## 6.0 MATTERS ARISING FROM THIS STAGE 1/2 ROAD SAFETY AUDIT

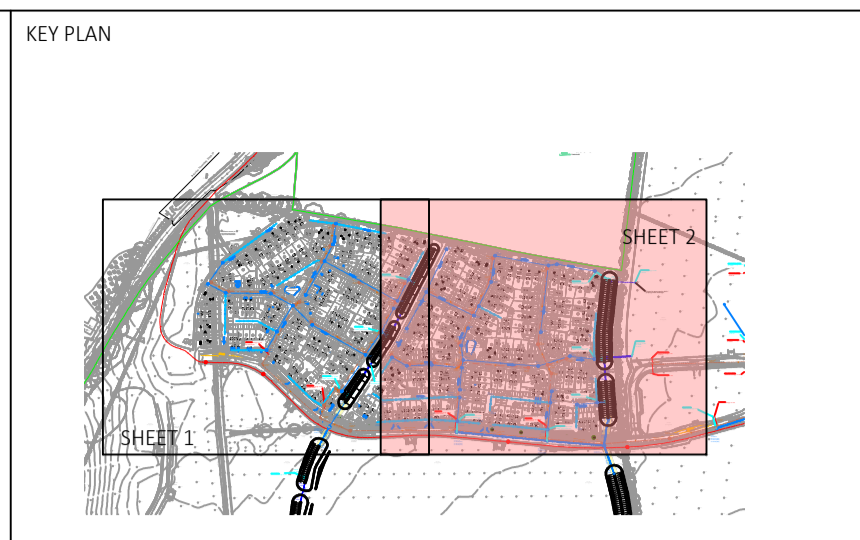
The drainage drawings submitted for audit show several attenuation features throughout the development adjacent to the carriageways. It is noted that some of these ponds are over 2.0m deep. If an errant vehicle were to enter the pond it may overturn as travelling down the side slopes (gradients unknown) and the occupants could drown if the ponds were holding water at that time.

It is recommended that some form of fencing is included in the design alongside the ponds.

450mm Knee rail has been specified around all attenuation basins. ROSPA report to be completed and larger fencing to be erected if deemed necessary.

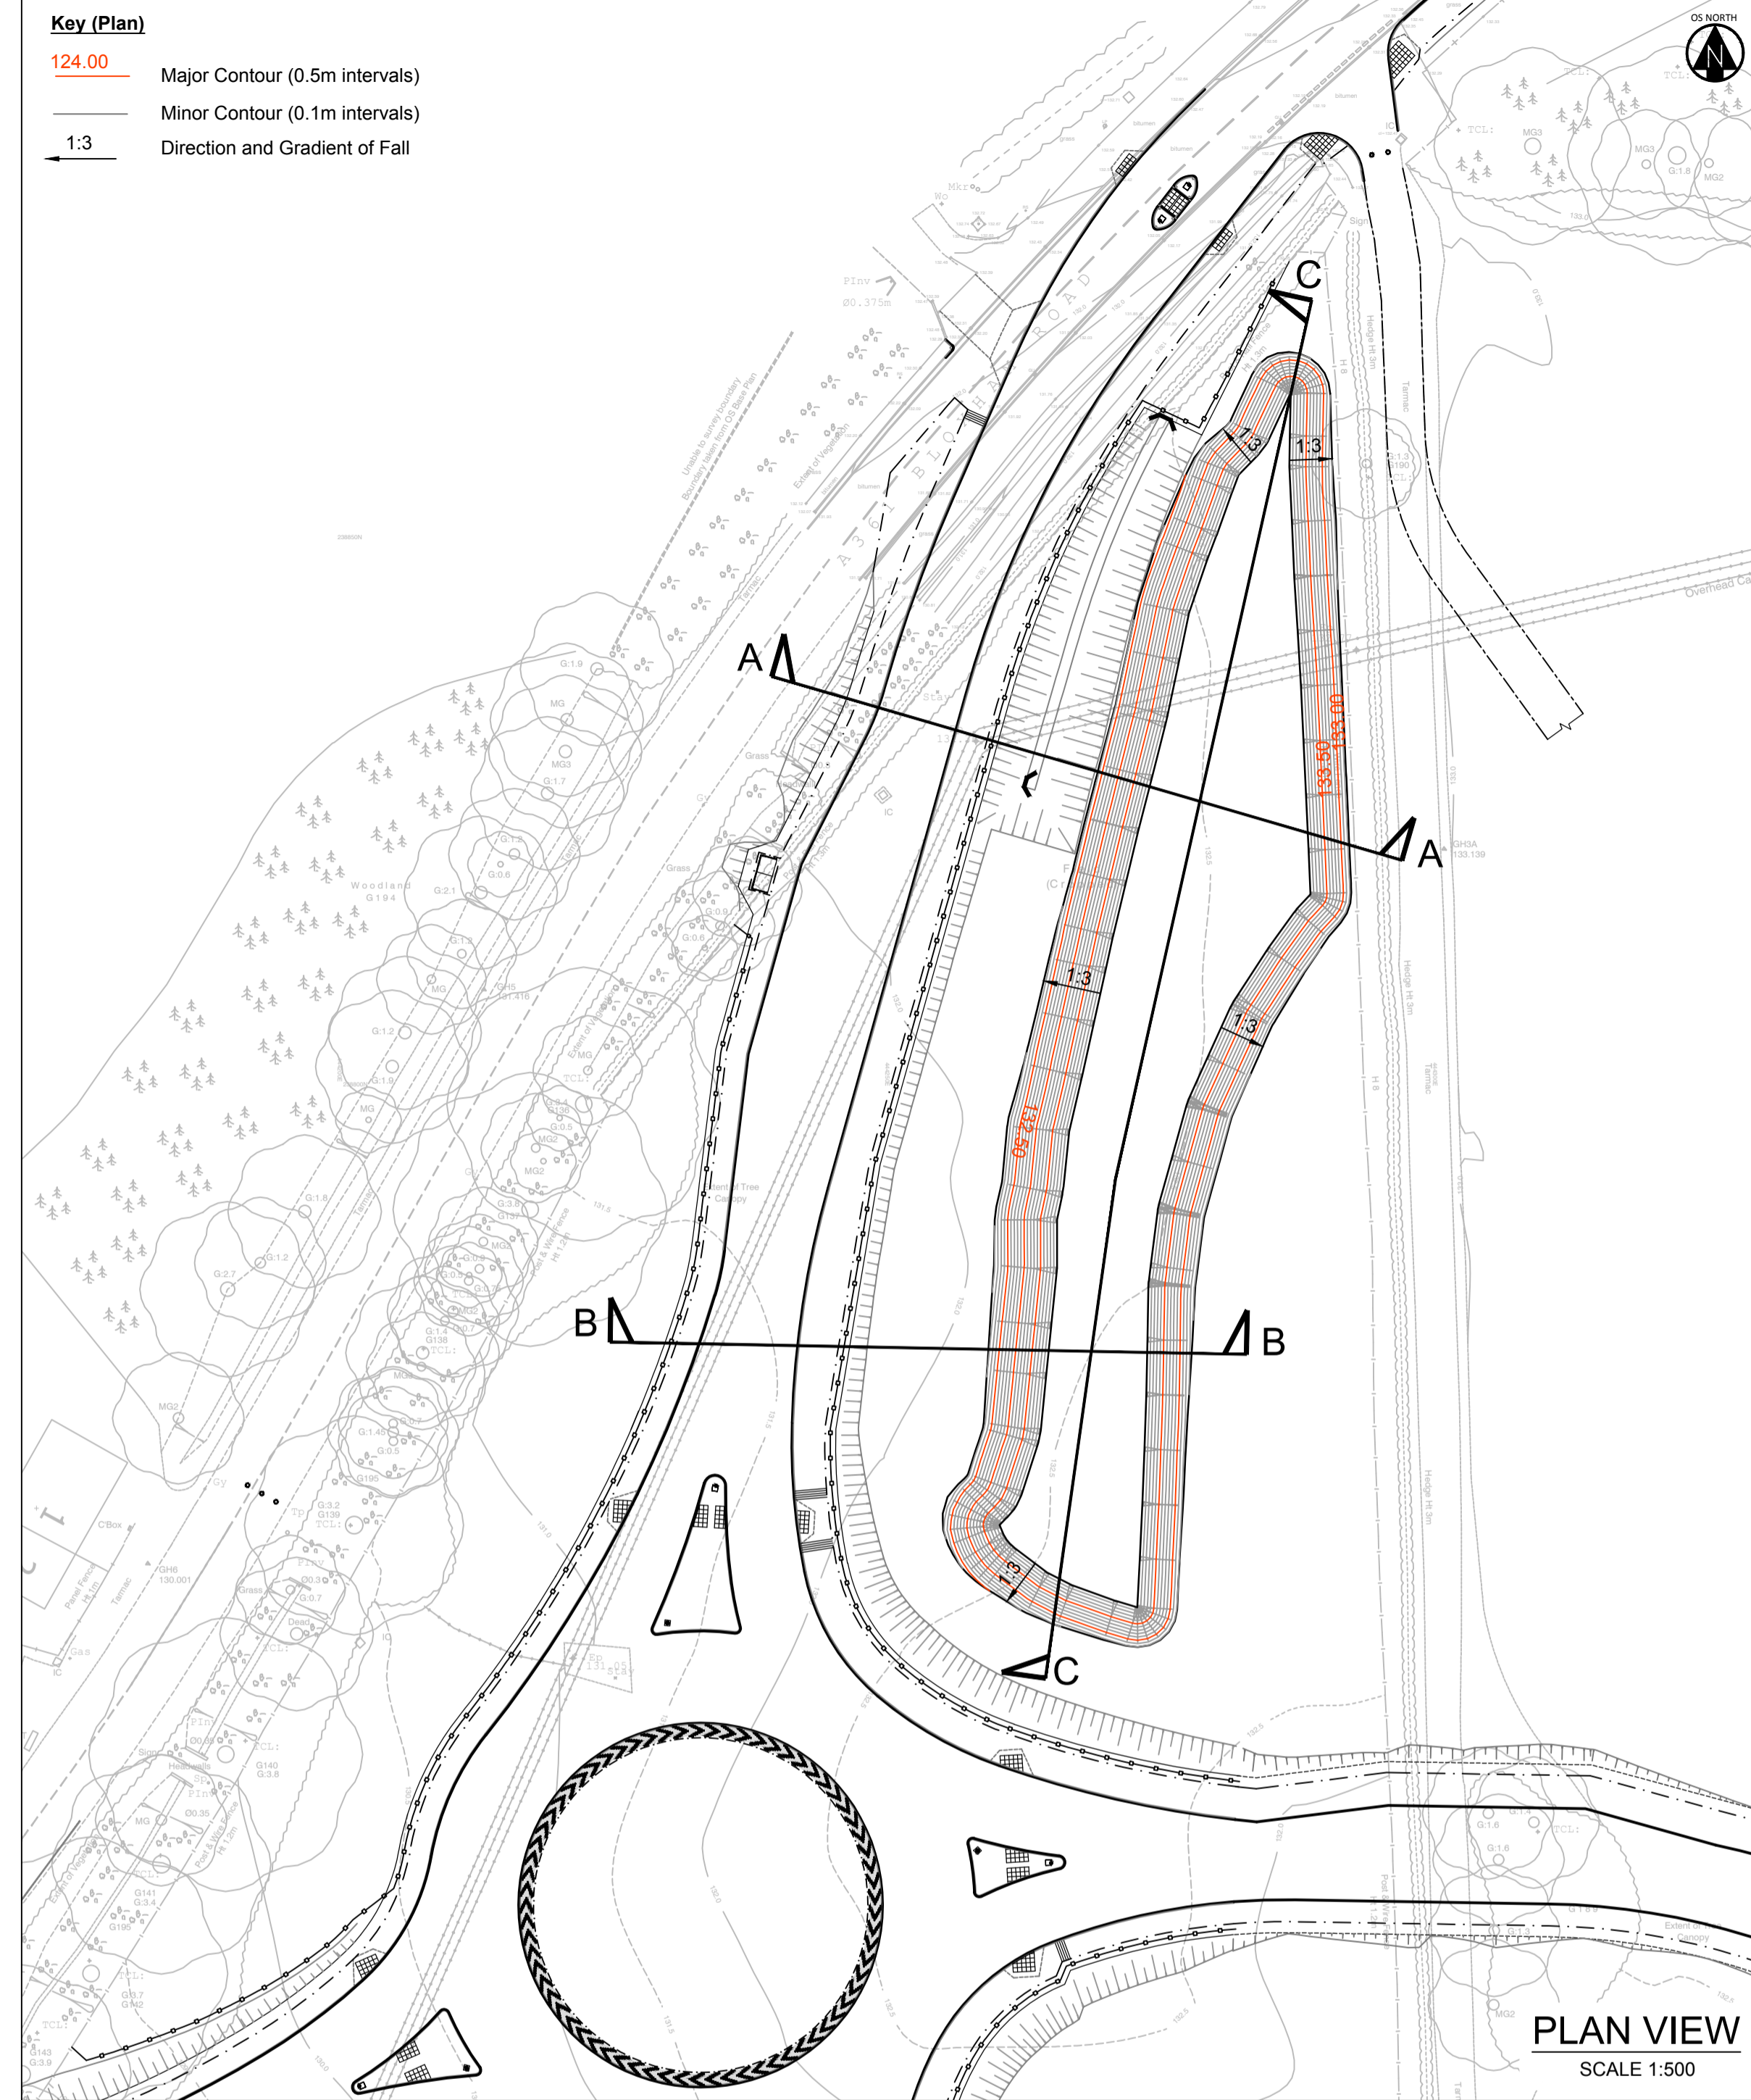
The footway running alongside the attenuation basins does not appear to have any fencing to prevent pedestrians falling into them. As the basins are over 2m deep in places there could be a risk of drowning. It is noted that the side slopes are between 1:3 and 1:4 but the gradient alongside the footway it is not clear.

It is recommended that the basins either be guarded or of a suitable gradient so that, if a pedestrian were to enter, they could climb out again unaided.

Basins will be guarded and will have a maximum gradient of 1 in 3 which is deemed safe and maintainable.
